Re: AW/43/18/OUT

5 Countisbury Close, Aldwick, Bognor Regis.

*proposed site plan*

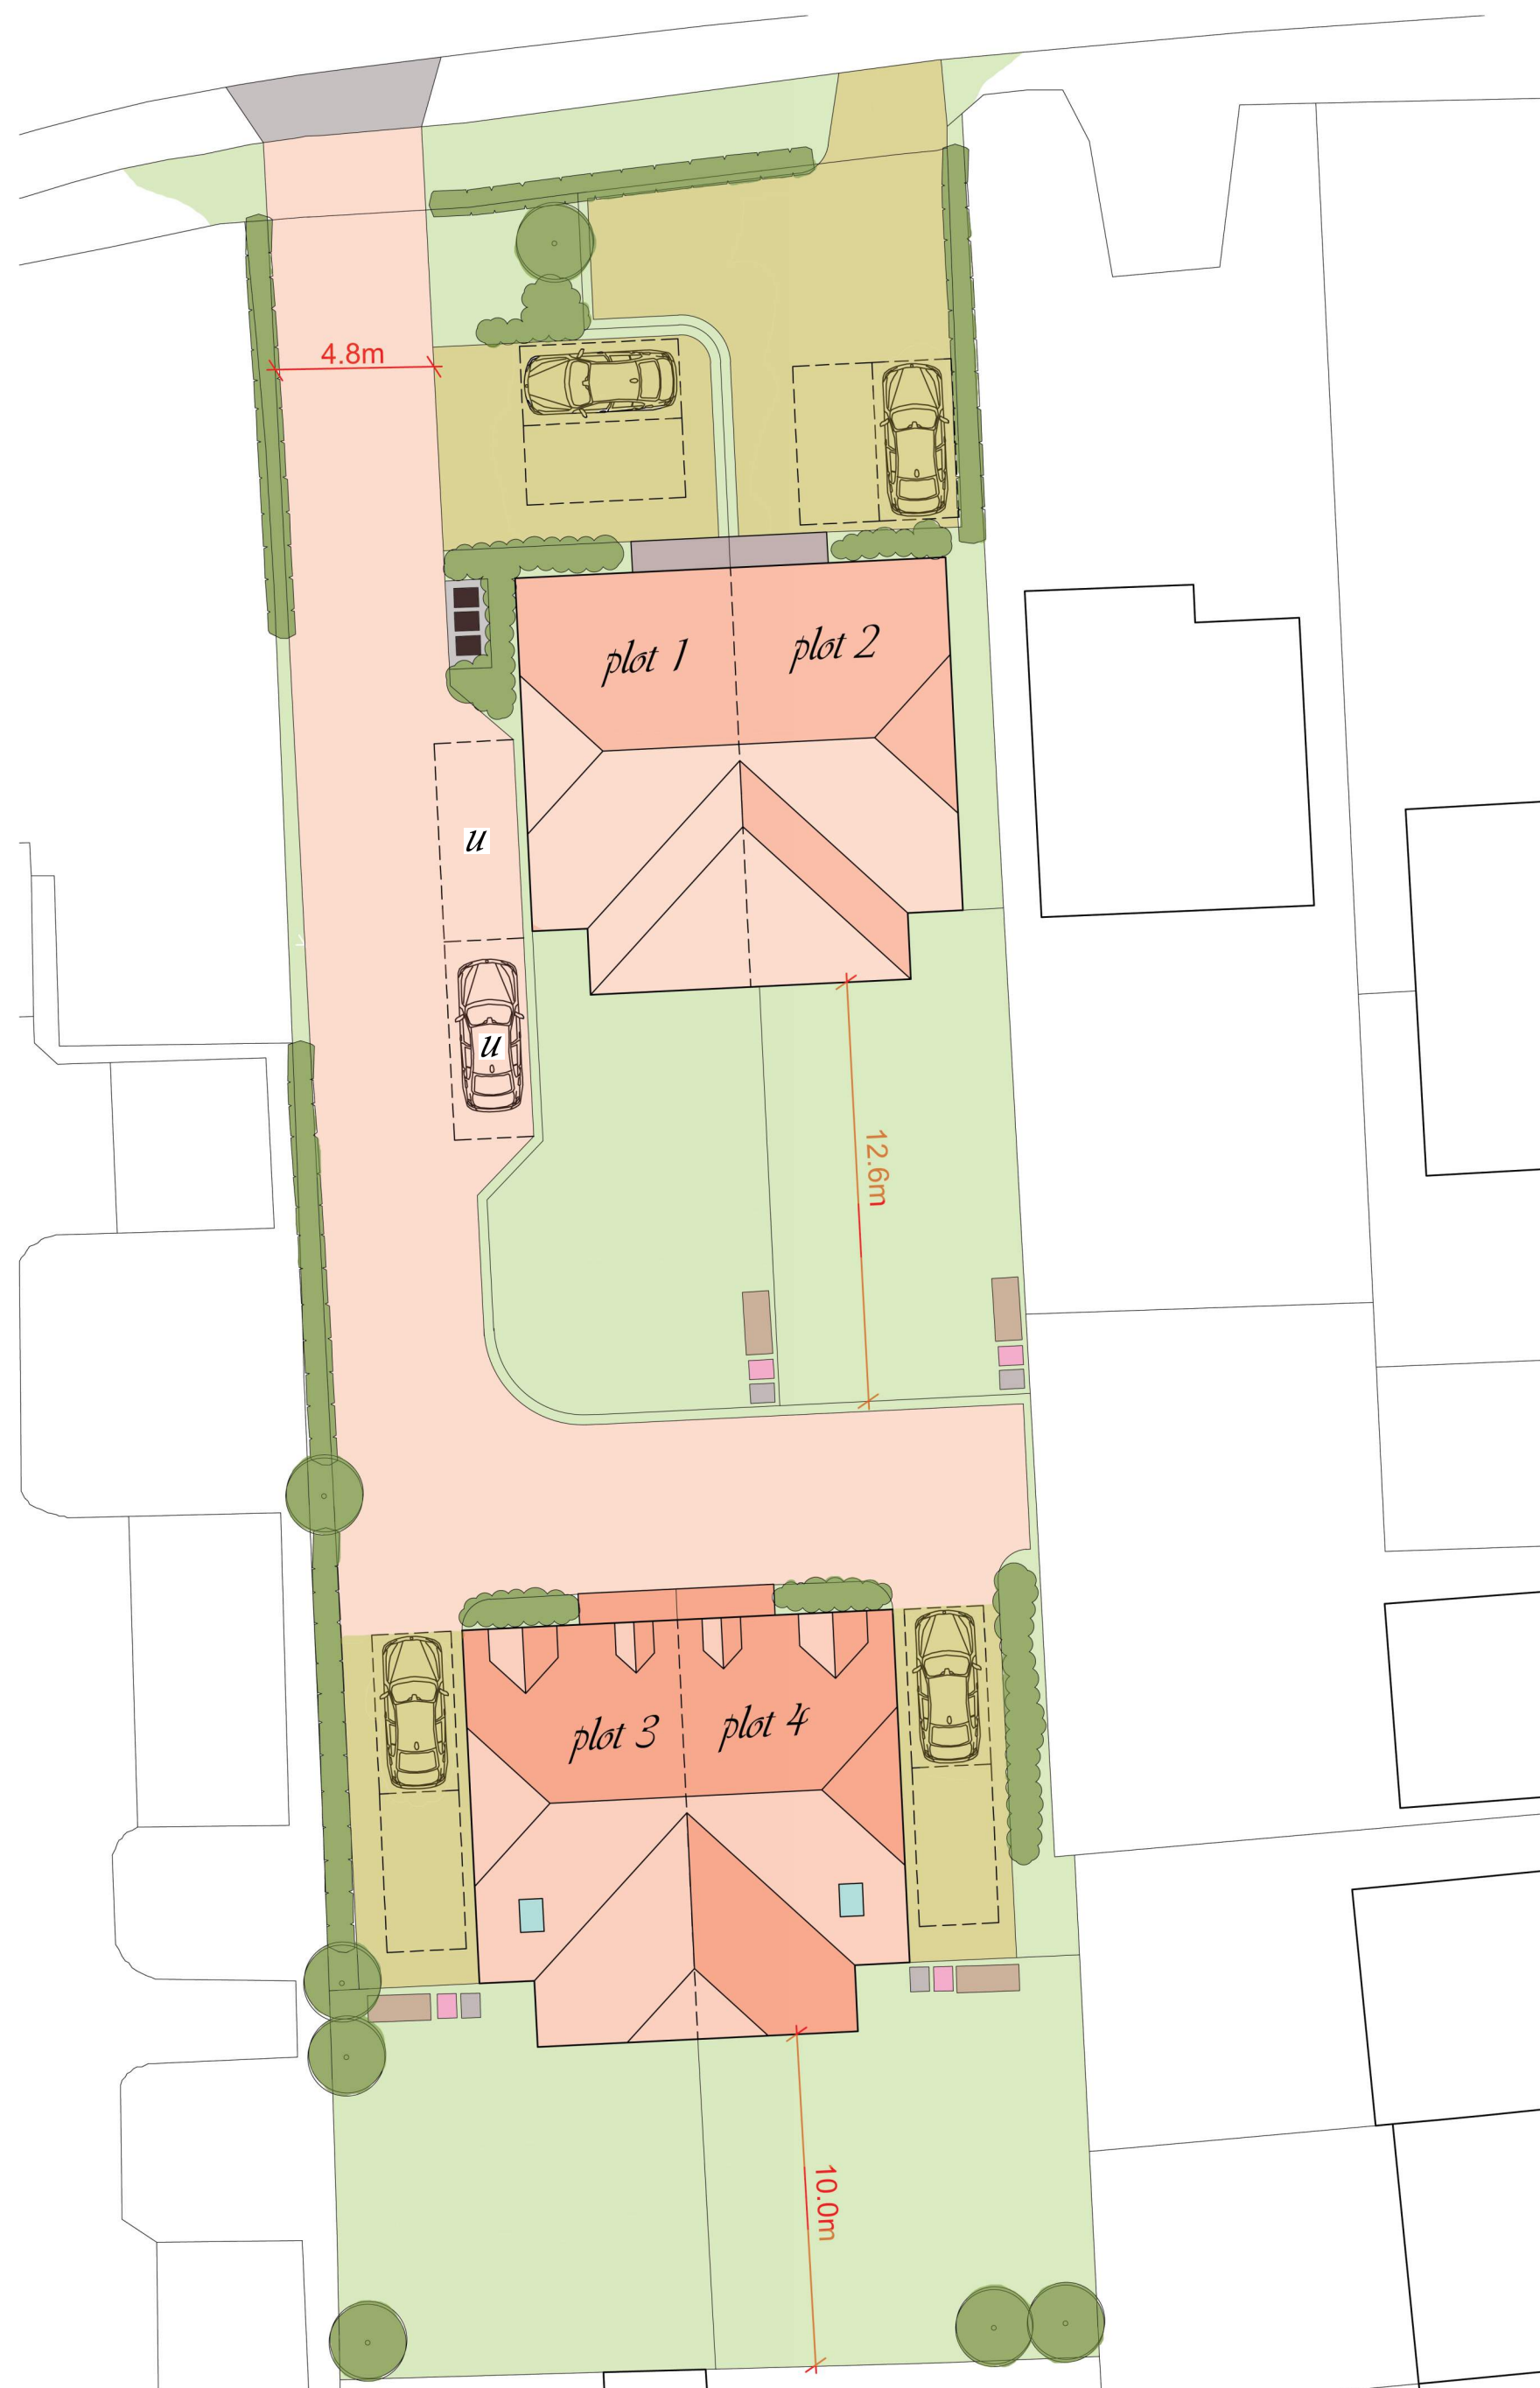
The proposed parking and access road runs right along our back gardens. Having vehicles parked so close will mean further increase noise when washing or servicing these vehicles and most new families moving into our road have between 2 and 4 extra cars or vans. Not the single as one shown for each property especially as they are all 4 bedroom houses. Not starter homes as really required these days. Severe increased pollution and noise will be the result if the proposed development goes ahead and no benefit for us who have to suffer this for the rest of our lives.

As I have mentioned in many objection letters the outline drawings displayed **are not to scale and representative of the actual location and impact** should this development go ahead. The properties in Countisbury Close are not as shown and how small our back gardens are. The proximity of such a large development and impact cannot be appreciated and would overwhelm us.
